Re: BusConnects Belfield/Blackrock to City Centre Core Bus Corridor Scheme

We now enclose herewith copy of the submission prepared by Simon Clear & Associates Planning Consultants on behalf of our client regarding Wappinger Food Corporation Limited and the Bus Connects Belfield/Blackrock to City Centre Core Bus Scheme – Herbert Park/Merrion Road Junction.

Re: Submission for Bus Connects Belfield/Blackrock to City Centre Core Bus Corridor Scheme – Herbert Park/Merrion Road junction.

Programme Title: BUSCONNECTS DUBLIN CORE BUS CORRIDORS INFRASTRUCTURE WORKS			
Drawing Title: BELFIELD / BLACKROCK TO CITY CENTRE CORE BUS CORRIDOR SCHEME LANDSCAPING GENERAL ARRANGEMENT			
Drawing File Name: BCIDC-ARP-ENV_LA-1415_XX_00-DR-LL-0016	Sheet Number: 16 of 23	Status: A	Rev: M01

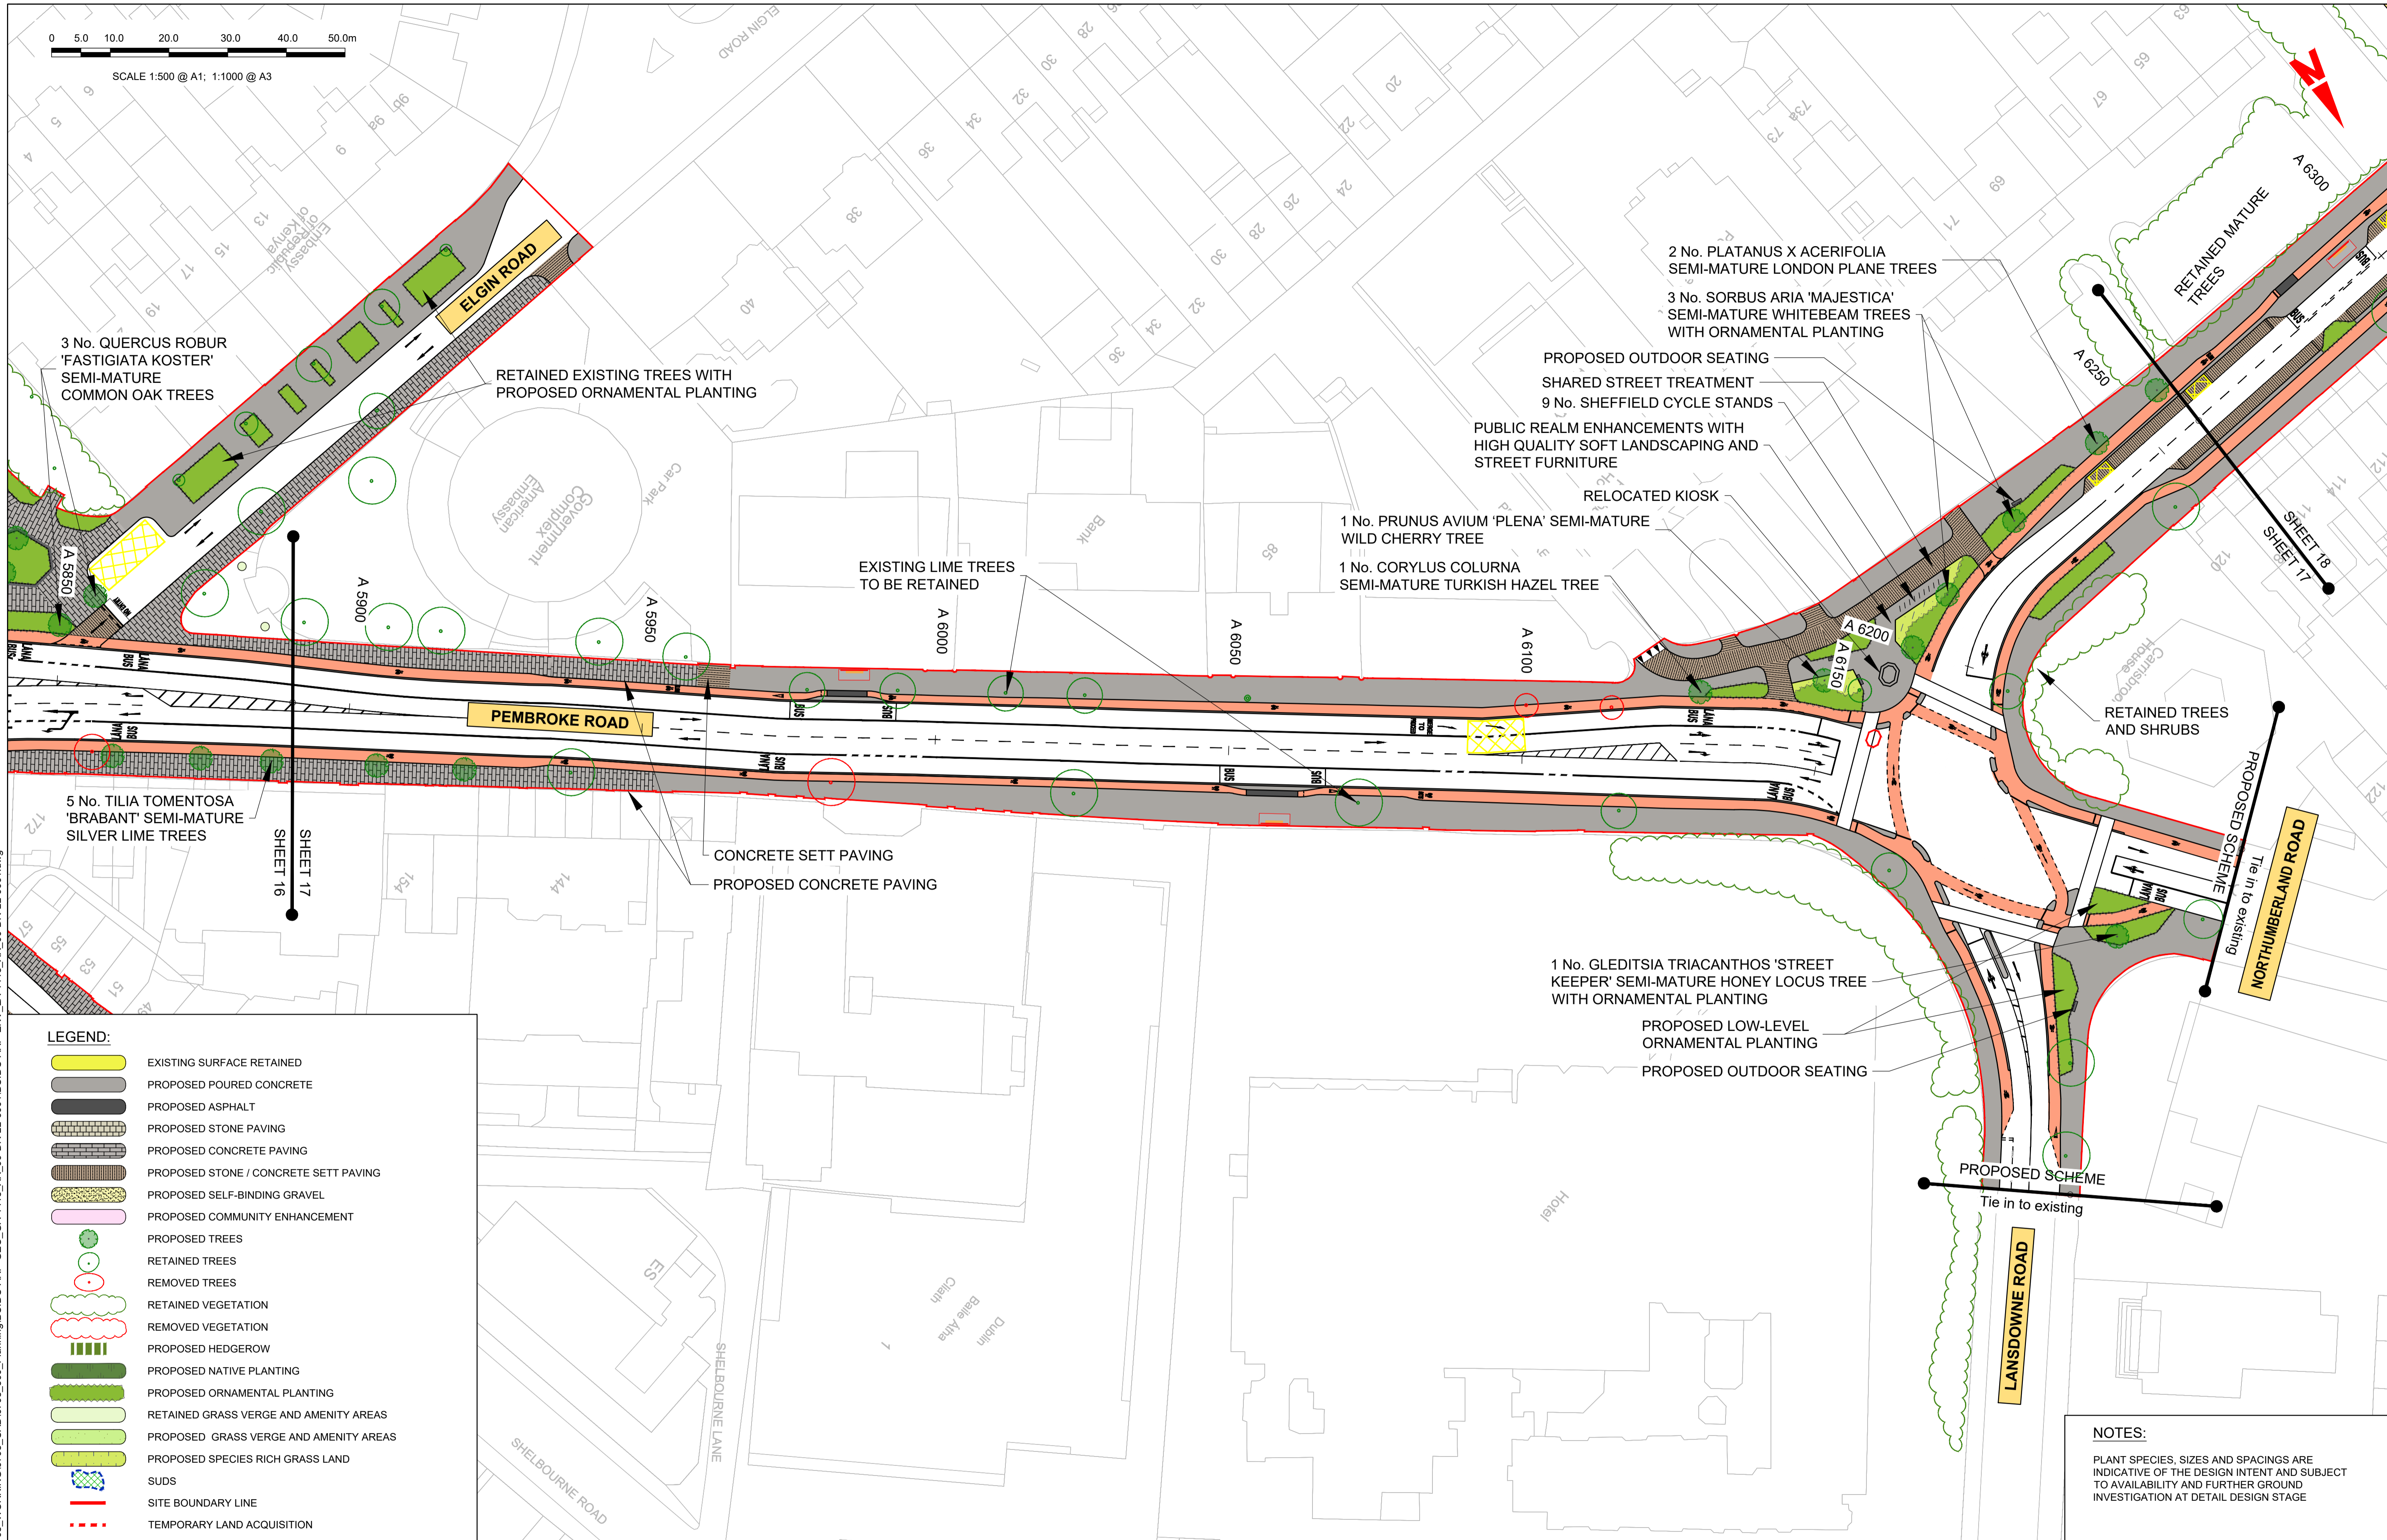
The Landscape General Arrangement Drawings indicate the nature and extent of proposed habitat removal. Sheet 16 indicates with red bubbling the removal of 'trees and shrubs' adjacent to Roly's.

The park adjacent to Roly's supports a (treeline) habitat of ecological significance, which habitat is acknowledged in the EIAR to be uncommon in the surrounding area. The EIAR (Table 12.5) assesses the potential impact on this habitat as a 'Likely significant effect at the local geographic scale'.

Treelines in urban environments are commonly used by bats for roosting, foraging and

commuting. The potential impact of the removal of this habitat at this location on bats has

not been assessed in the EIAR.

As the tree-felling is a compounding issue that is unnecessary with these suggested

alignment adjustments the impact on bats, which has not been assessed in conjunction with

this aspect of the proposed development, would be significantly mitigated.

It is requested that the NTA scheme designers take account of the structure that exists and

make appropriate adjustments to retain the structure with less modification on the Herbert

Park side, with a curved approach to the proposed modified junction.
